Subject: RE: Planning Consultation on: LU/163/20/PL

Please see comments below from Private Sector Housing.

Application No: LU/163/20/PL

Registered: 2nd July 2020
Site Address: 6 Selborne Place Selborne Road Littlehampton BN17 5NH
Grid Reference: 503276 101647
Description of Works: Demolition of existing conservatory, single storey front & rear extensions & change of use from HMO (Sui Generis) to 5 No. flats (4 net) (C3 Dwelling house). This application affects the character & appearance of the Littlehampton Seafront Conservation Area & may affect the setting of a listed building. This application is not CIL Liable as flats in Zone 4 (Zero Rated).

Proposed Second Floor Plan 1:50

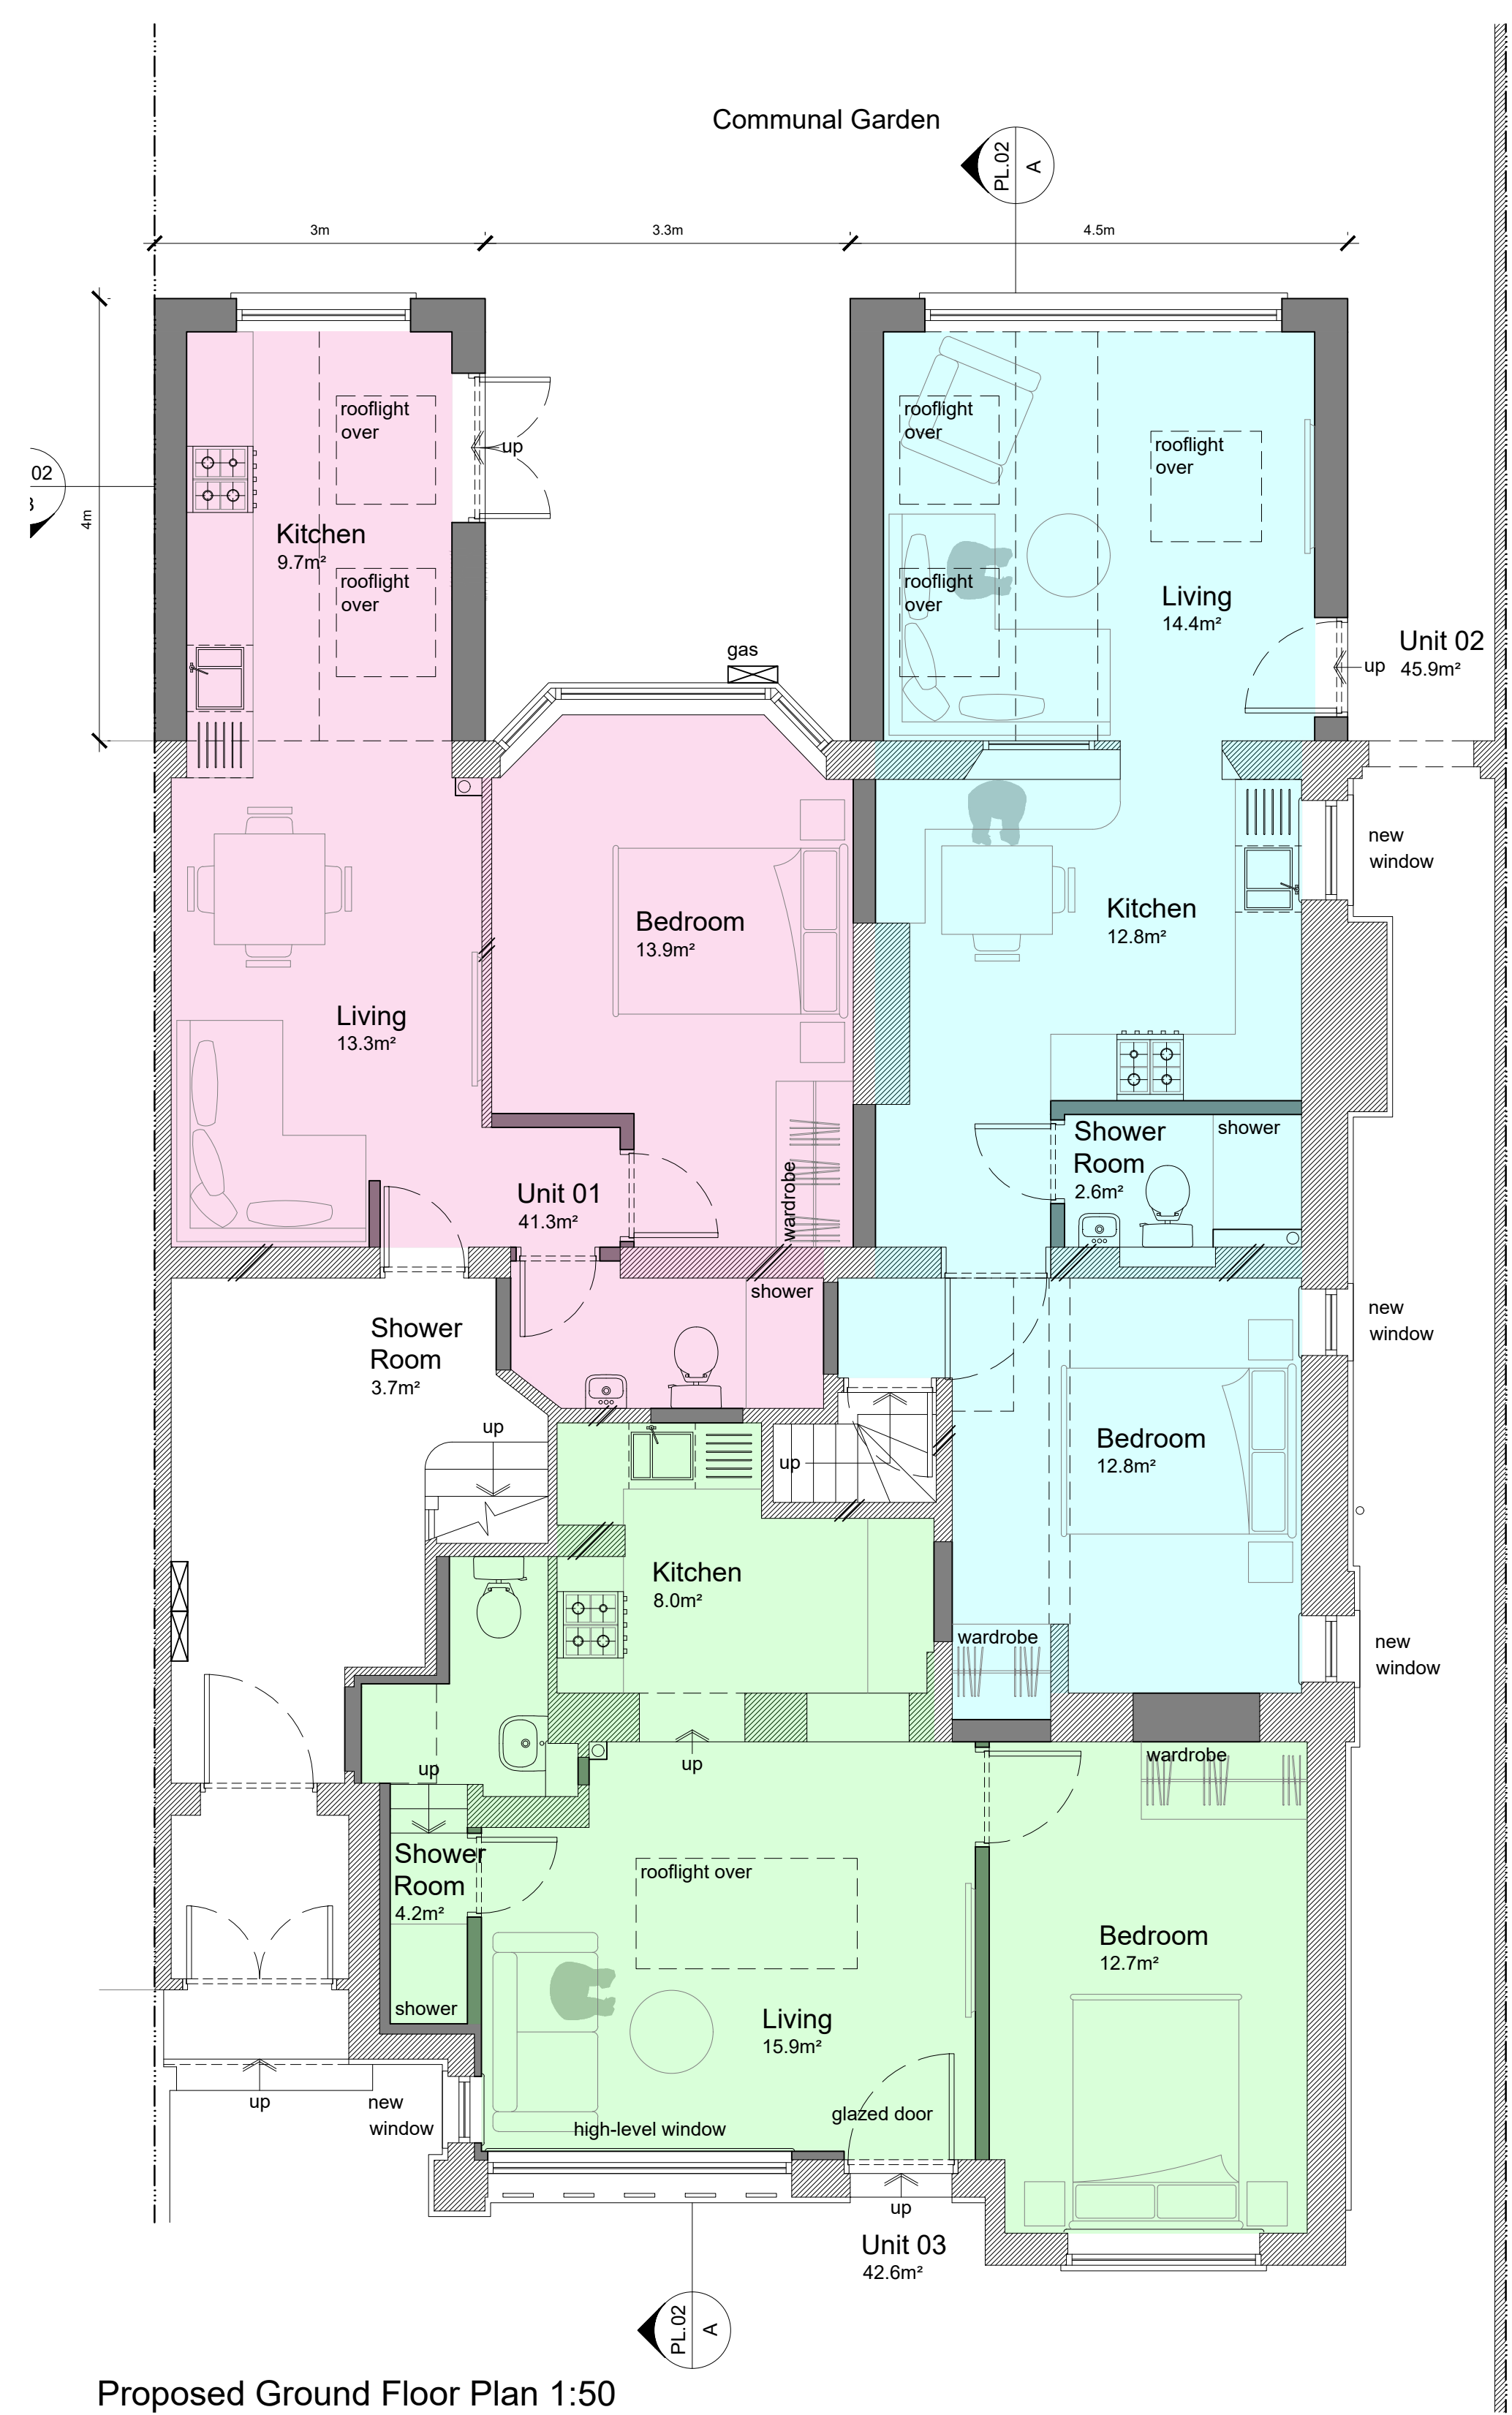
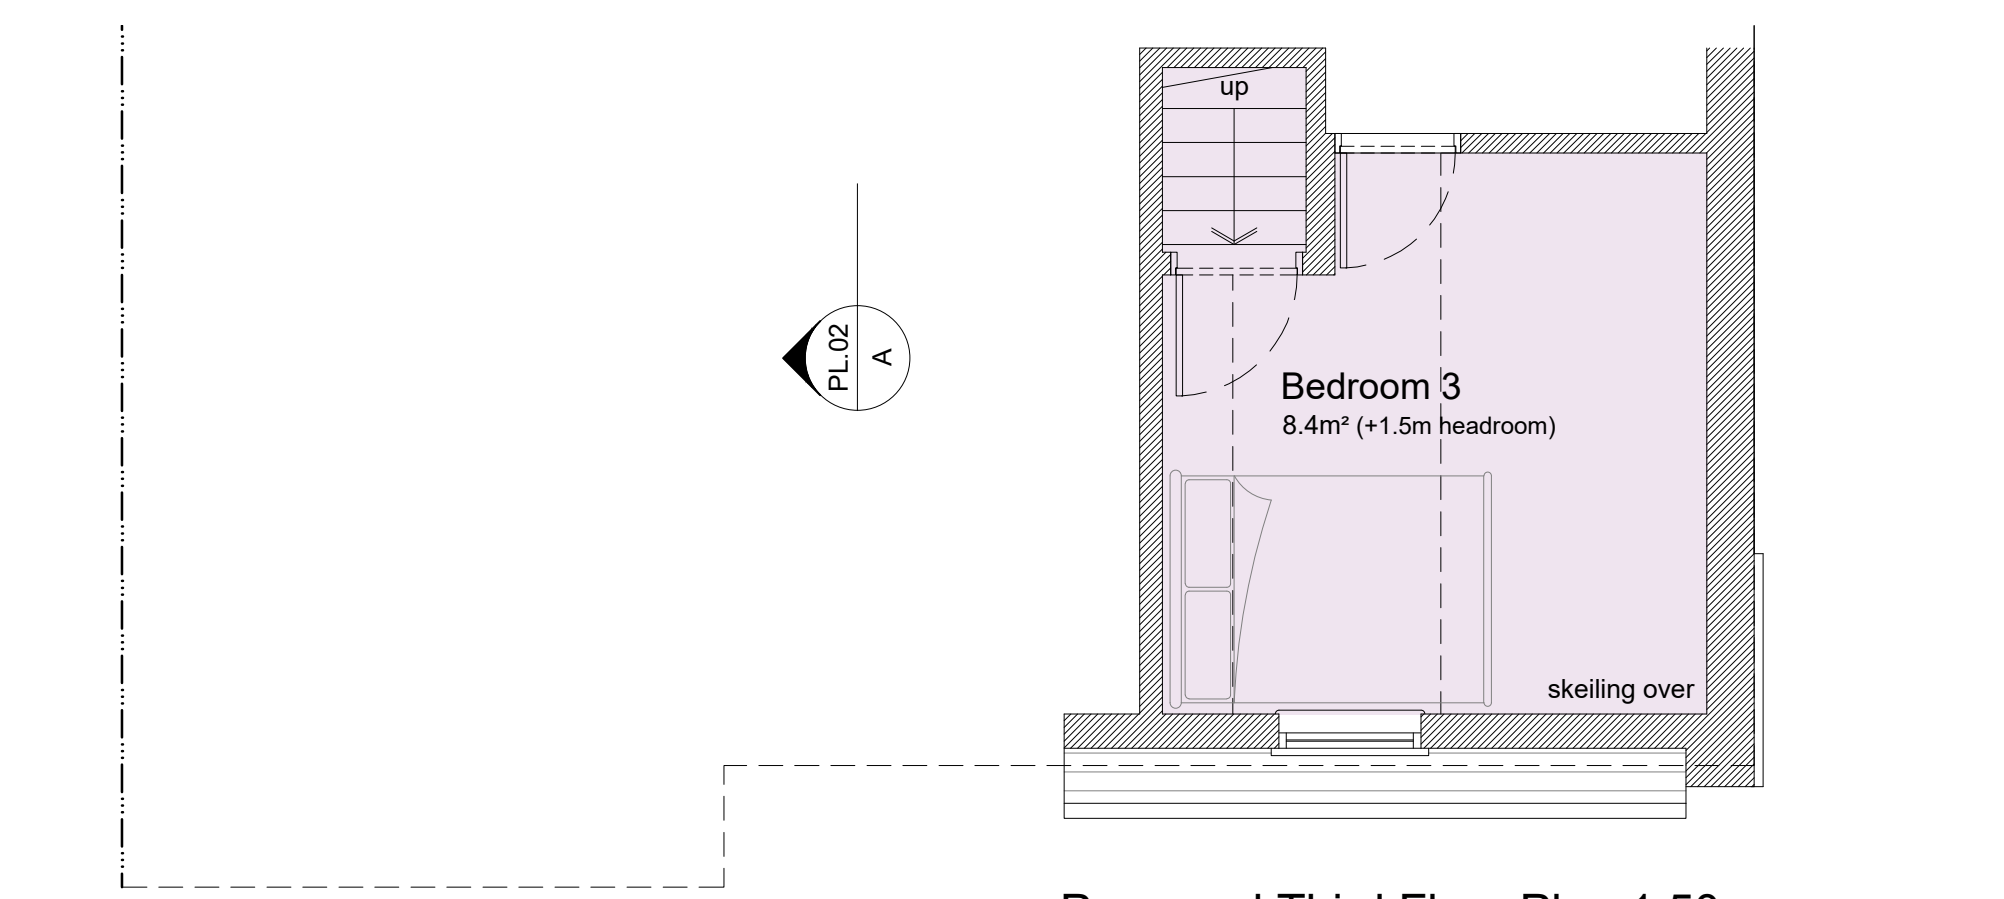
- A room where the only escape route is through another room is termed an “inner room” and poses a risk to its occupiers if a fire starts unnoticed in the outer room. The escape route from the bedroom in Unit 02 is via the kitchen; this can be overcome by ensuring that the window in the bedroom is an escape window and there is adequate fire protection within the flat. However, an escape window should only be installed if the following criteria can be met:

- The window should lead to a place of ultimate safety
- 30 minute fire resisting escape route should be provided, including 30 minute fire resisting and self-closing fire doors (FD30S) to Units 01, 04 & 05 (Units 02 & 03 have their own private entrance) and electrics to be enclosed in fire resisting compartment

- There appears to be part of a staircase above the kitchen in Unit 03. If this is indicating the steps in the bathroom in Unit 04 above, then no other action is required. However, if the stairs are in relation to an escape route, the underside of the staircase within Unit 03 will need to be underdrawn to ensure it affords 30 minutes fire resistance

- Kitchens should have adequate mechanical ventilation
- Mechanical extraction should be provided to all bathrooms/shower rooms/en suites
